**Transport
for NSW**

**Sydney International Convention Exhibition and Entertainment Precinct (SICEEP) -
The Haymarket, Residential Building (Student Accommodation) - SSD 6010**

Thank you for your letter dated 14 January 2014 regarding the above. Please accept our letter as a joint Transport for NSW (TfNSW), Roads and Maritime Services (RMS) and RailCorp comments on the response to submissions for the above proposal.

Figure 3.5.1 Darling Drive

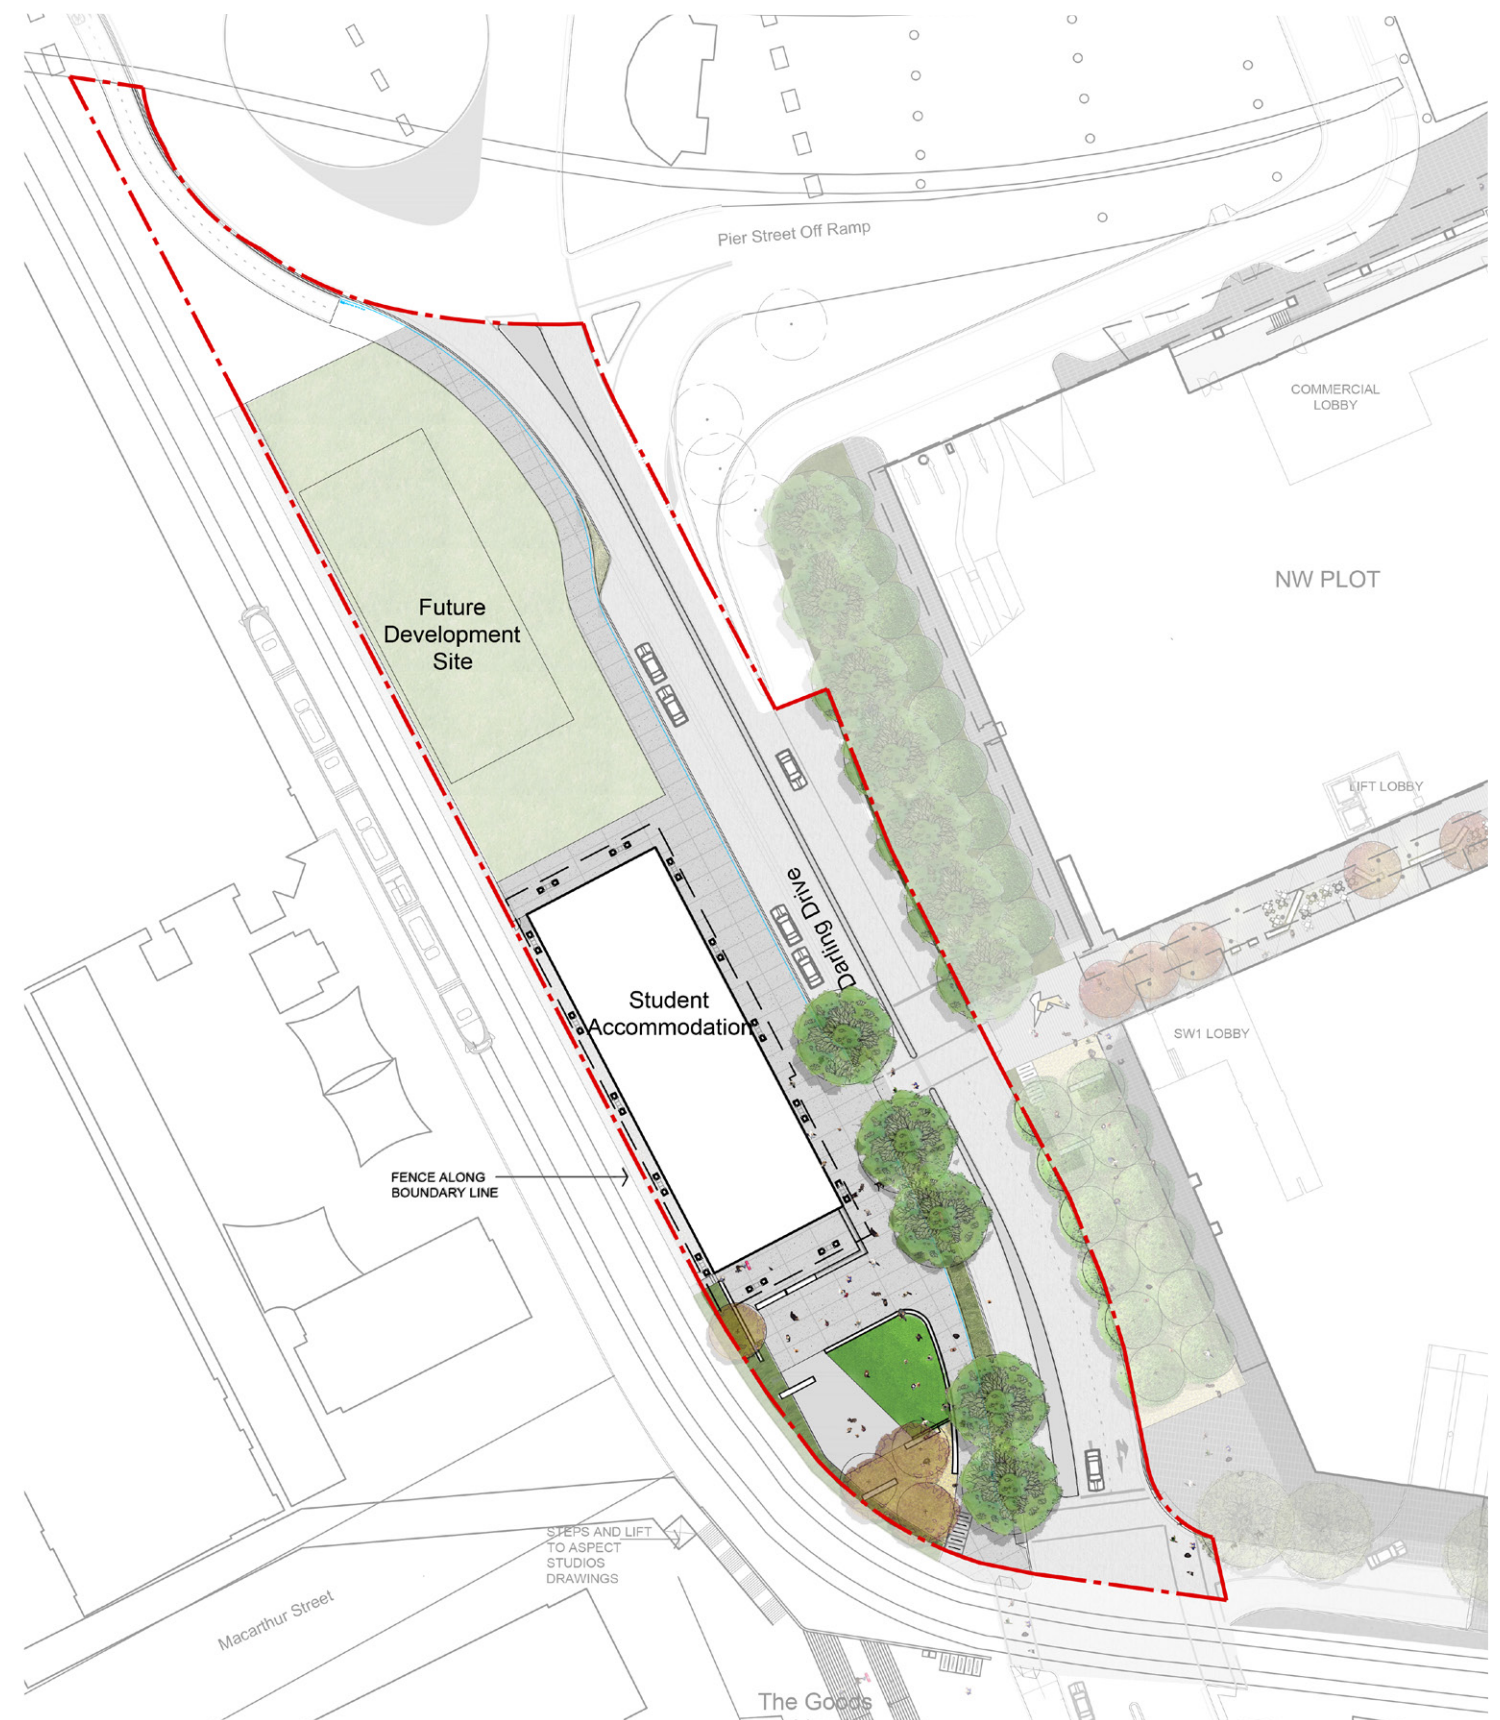
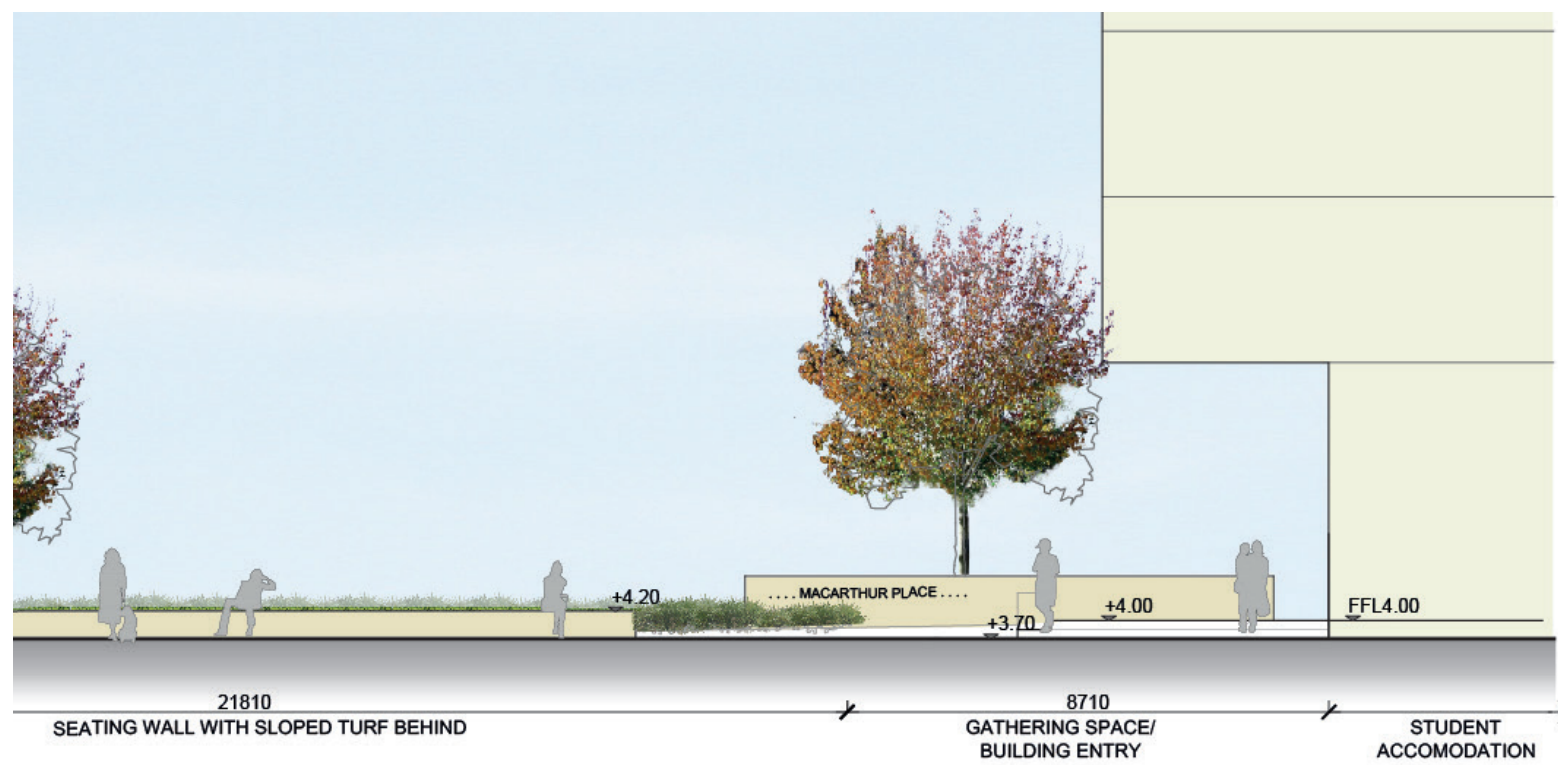
- Based on *Transport and Traffic Impact Assessment Addendum Report* dated 7 January 2014 prepared by Hyder Consulting as part of the responses to submissions (Drawing SKCPD083), the width of the shared walk and cycle path is 2.5m-3m compared to minimum required overall width of 3.5m for commuting and recreational path (includes 1m wide cycle paths for each direction of travel and 1.5m wide footpath for frequent and concurrent use in both directions) based on Austroads *Guide to Road Design, Part 6A – Pedestrian and Cyclists Path*. Therefore, for safety and network efficiency reasons, TfNSW requests that the 3m wide shared path be replaced, wherever it is possible, with either physically or visually (line marking) separated walking and cycling paths along the western side of Darling Drive during detailed design stage. In addition, consideration should be given to use different colours

or pavement materials to distinguish between footpath and cycling paths. Placing appropriate advisory signs or stencils (pavement logos) would help raising awareness and encourage better behaviour from path users.

- Darling Drive cycleway is part of the future city centre cycleway network. A shared path outside the new buildings has the potential to increase pedestrian/cyclists conflicts due to cyclist volumes and speeds on Darling Drive shared path. The proposed shared path located in close proximity of a building with large numbers of people entering/exiting would likely to increase pedestrian/cyclists conflicts. TfNSW requests the proponent to investigate a segregated cycleway adjacent to the traffic lanes on the western side of Darling Drive through further re-alignment, reducing the median and considering the shoulder reduction on the eastern side of Darling Drive. Configuring the 15 min zone may also be an option to be considered to accommodate a cycleway.
